Address: 23 Darnley Close Holmfirth HD94BT

Application number: 2024/93114	
What is the application for?:	Demolition of existing garage and link structure and erection of two storey side
Address of the site or building:	21, Darnley Close, Meltham, Holmfirth, HD9 4BT
Postcode:	HD9 4BT

User comments

Proposed Site Layout
Scale 1:500

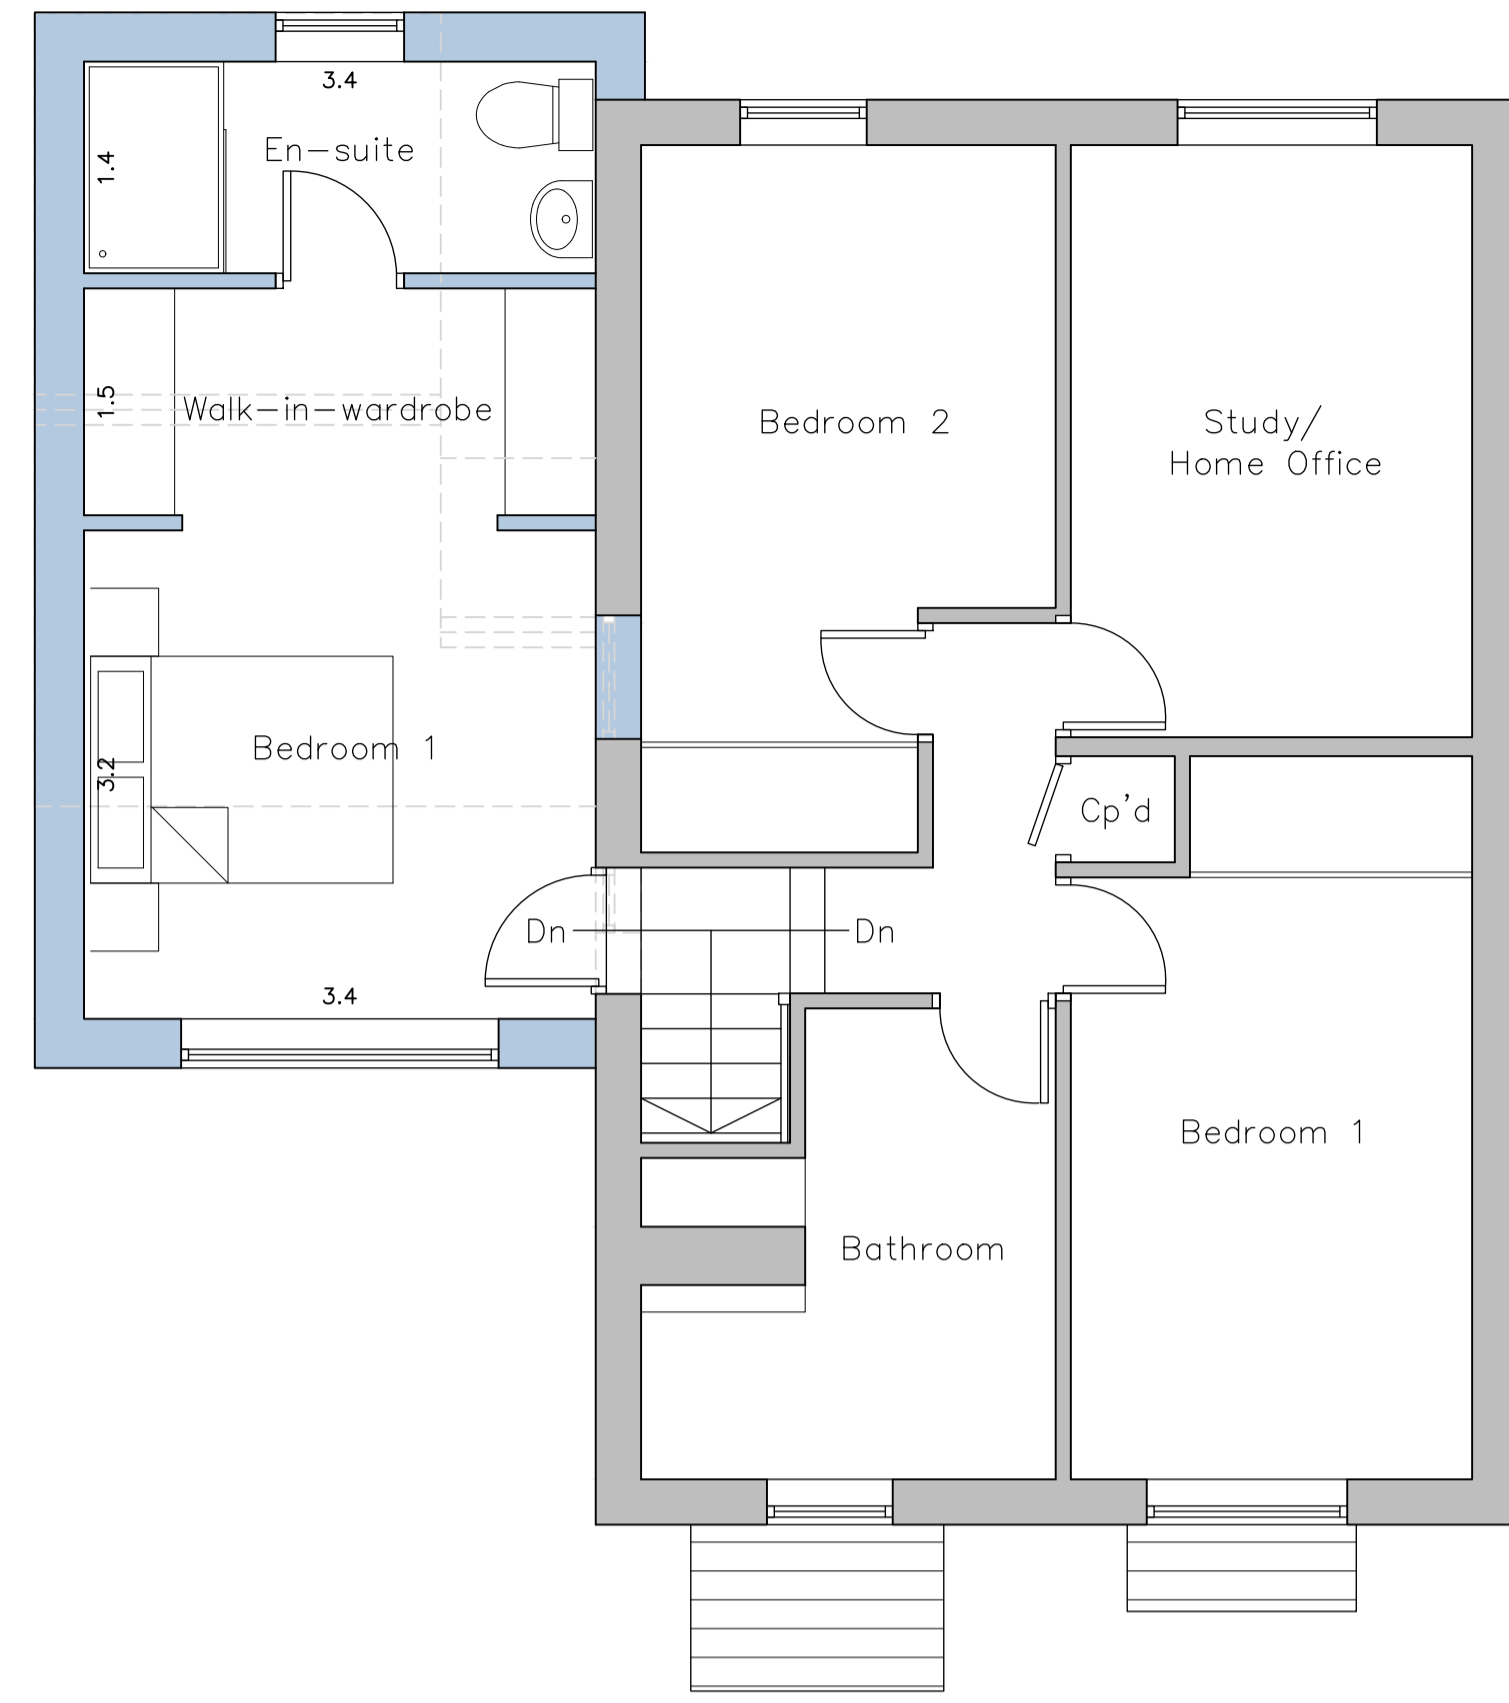
I view with disquiet the suggestion of a parking bay immediately adjacent to my land and protruding out onto what is, as can be seen, the driveway which is a shared right of way. Any vehicle parked there, even if back to the bay window of 21 will mean a narrowing of access to 19 and 21 to only slightly wider than the width of a vehicle. It is difficult at present for vehicles larger than a car to access the driveway so delivery vehicles, ambulances, etc. would not be able to get through to 19 and 21 even if it is only a smaller car parked in that bay. Incidentally, Mr McNulty's bay window isn't shown on the plan provided. Parking a car in this bay will require anyone parking in front of my left-hand garage to undertake awkward reversing manoeuvres to leave the site or perform a reversing manoeuvre on arriving in the cul-de-sac onto the drive around the tight curves to number 23.

No permission will be granted for vehicles to park outside the original boundaries as drawn up on the title deeds for number 23, viz, a continuing straight line leading from the end of the left-hand garage to the bottom fence.

Although it doesn't directly affect number 23, at present it is only through good will that number 19 can manoeuvre their vehicles out of their corner because of the problems already mentioned. It would seem that the extension of Mr McNulty's garage forwards on a cramped site to allow larger new rooms above will adversely affect the ability of number 19 to gain access to/from their own drive.

In conclusion, my major concern is the construction of a parking bay adjacent to my property which restricts an already cramped driveway and makes manoeuvring off my property more difficult. If Mr McNulty is able to manage without such a bay, is able to build an extension without creating permanent problems for number 19, and minimises the disruption for all of us during the construction period, I would support his planning application and hope he and his family will be very happy there.
